Your Ref: OWPC20252
Our Ref: W/104/18/HH 14-08-2018
Please ask for:
Stuart Corbey

Town & Country Planning Act 1990 (as amended)
Town & country Planning (Development Management Procedure) (England) Order 2015

Loft conversion
9 Allenye Way Elmer Middleton

REAR (EAST)

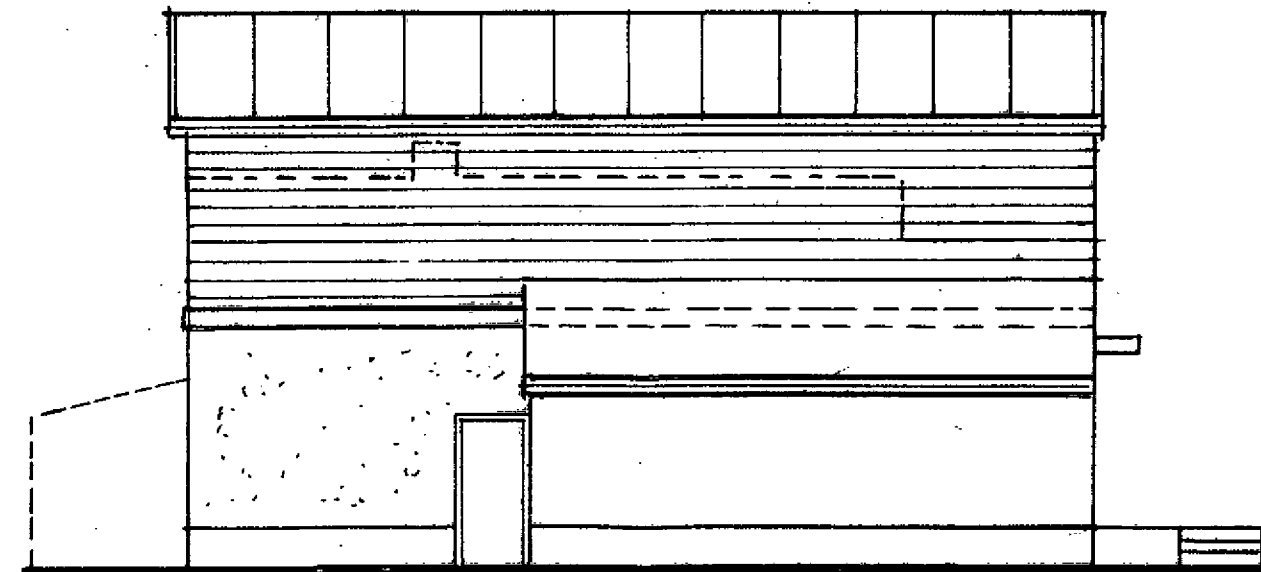
I live in the property immediately to the rear and the proposed loft conversion will result in my property being overlooked and my privacy compromised. Mr S Corbey, Planning Officer, visited me on 25 September 2018 took pictures from my garden and discussed with me the changes to the plans for the rear of the property that would minimise any overlooking. These required the use of opaque glass in all rear windows and the lowering of the door and/or the replacement of the rear door with lower fixed window using opaque glass. Overlooking and reduction in privacy are my only concerns.
